Approval of details reserved by condition imposed under ref APP/C3810/W/18/3197149 (LU/162/17/PL relating to Condition Nos 8 - materials & finishes, 9 - landscaping scheme, 10 - Construction Management Plan, 13 - visibility splays, 14 - pedestrian visibility plays, 16 - cycle parking and 18 - street lighting.

Land At Toddington Farm North And West Of 1 To 3 Toddington Toddington Lane Littlehampton BN17 7PN

Arun District Council have decided to **REFUSE details reserved by condition for the following reasons:**

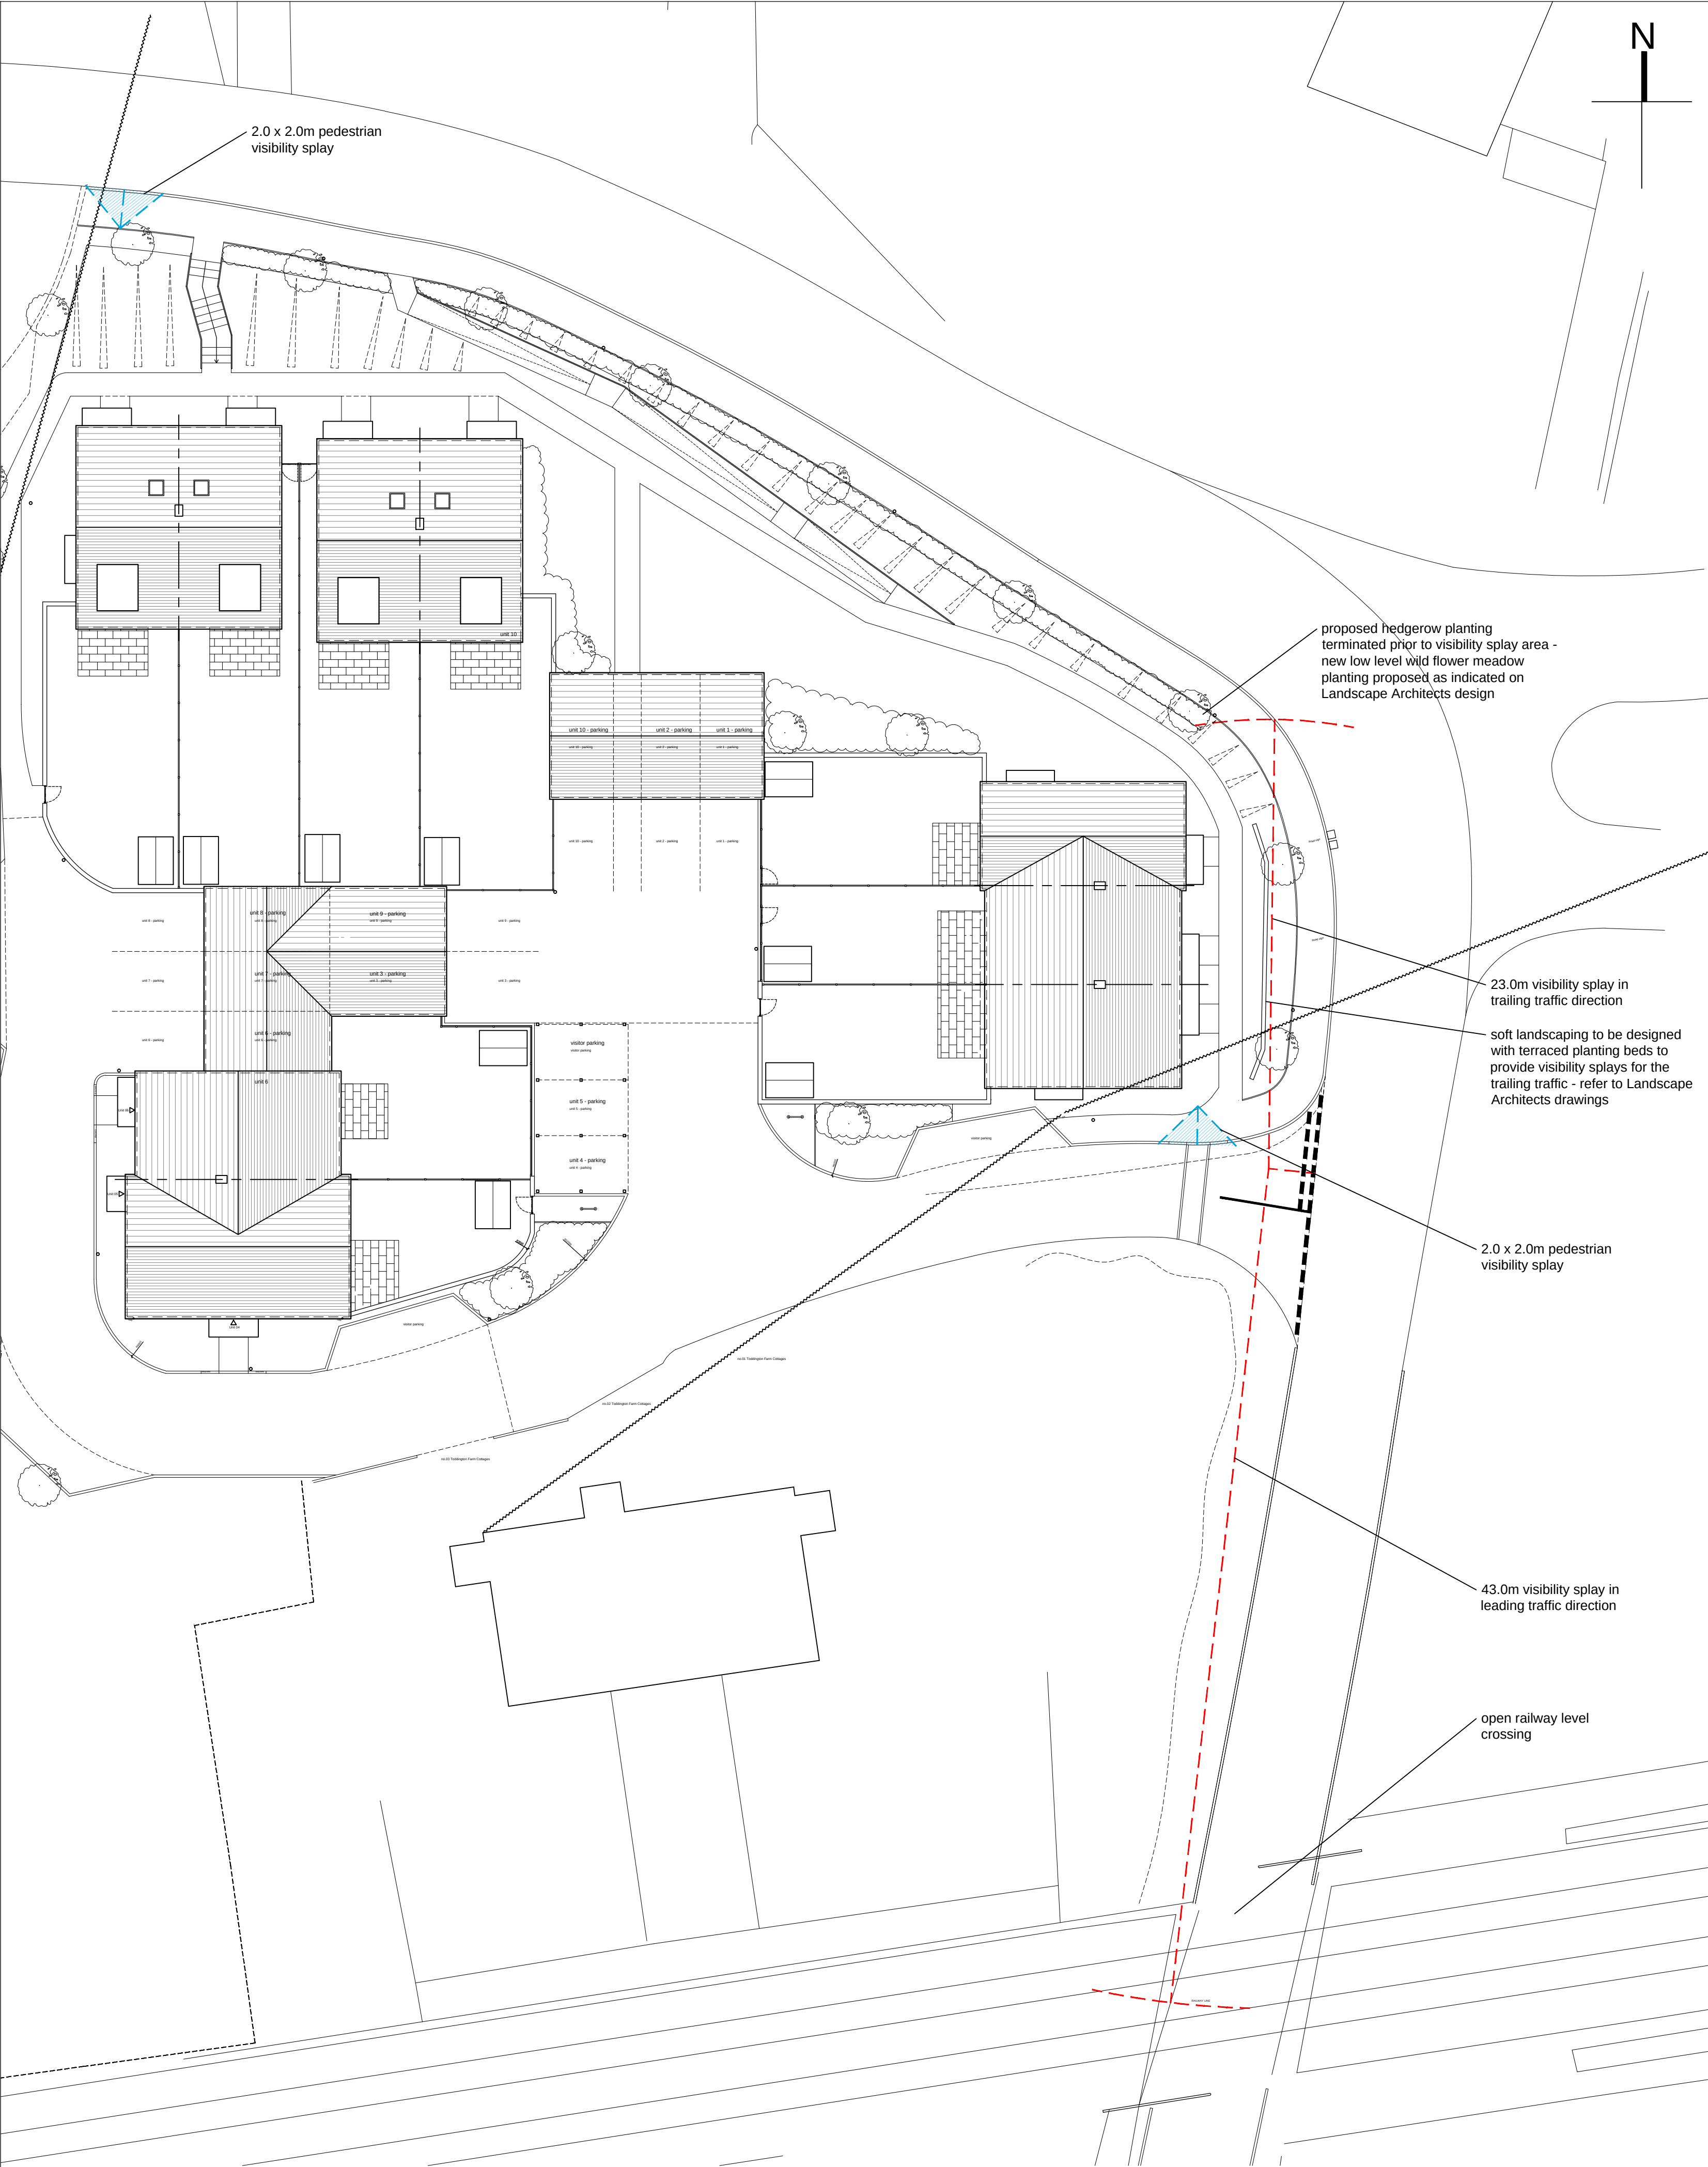
This condition is refused on the basis if the information submitted for the following reasons: The pedestrian visibility splays are shown incorrectly. They should be provided where access points (vehicular and pedestrian) emerge to the back-edge of any footway (i.e. the stairs and ramp). A further splay (suitable for peds/motorists) should be shown at the western-end of the proposed footway as this is where pedestrians will be interacting with the carriageway given that the footway terminates at this point.
